LU/46/26/DOC

Address: 5 Selborne Place Selborne Road Littlehampton BN17 5NH

Proposal: Approval of details reserved by condition under LU/234/25/PL relating to condition 3- Materials and Finishes.

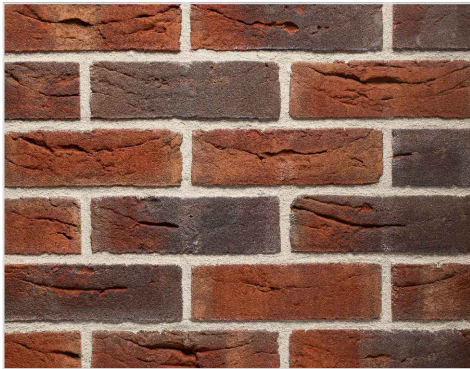
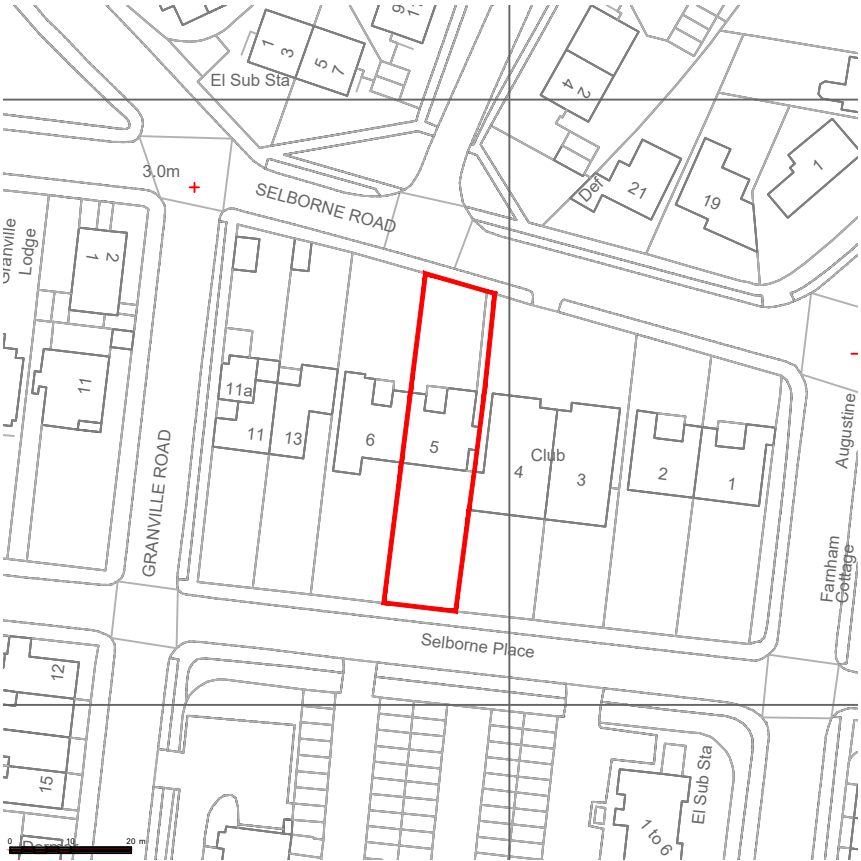
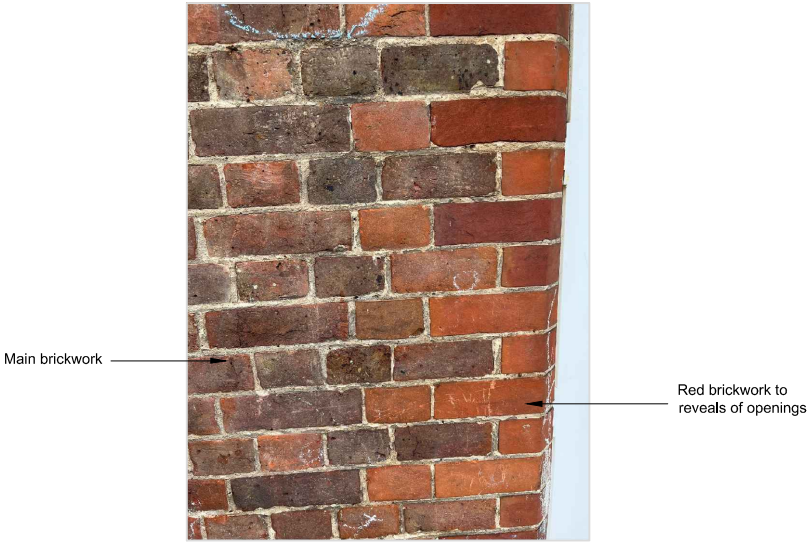
The proposed bricks look to be an acceptable match to the existing. However, the mortar specification will be important to ensure that the new brickwork matches the existing. It should be appropriate in terms of its colour and its joint profile/thickness. If the mortar were to differ

significantly in colour or if the joints were excessively thick, the result would be visually harmful. A mortar which matches the existing would be acceptable. Please could full details of the proposed mortar mix, colour and joint profile be provided.

It is also unfortunate that the window design makes it immediately apparent which of the casements will be openable. However, I believe that they will match or reflect those found on the remainder of the building?
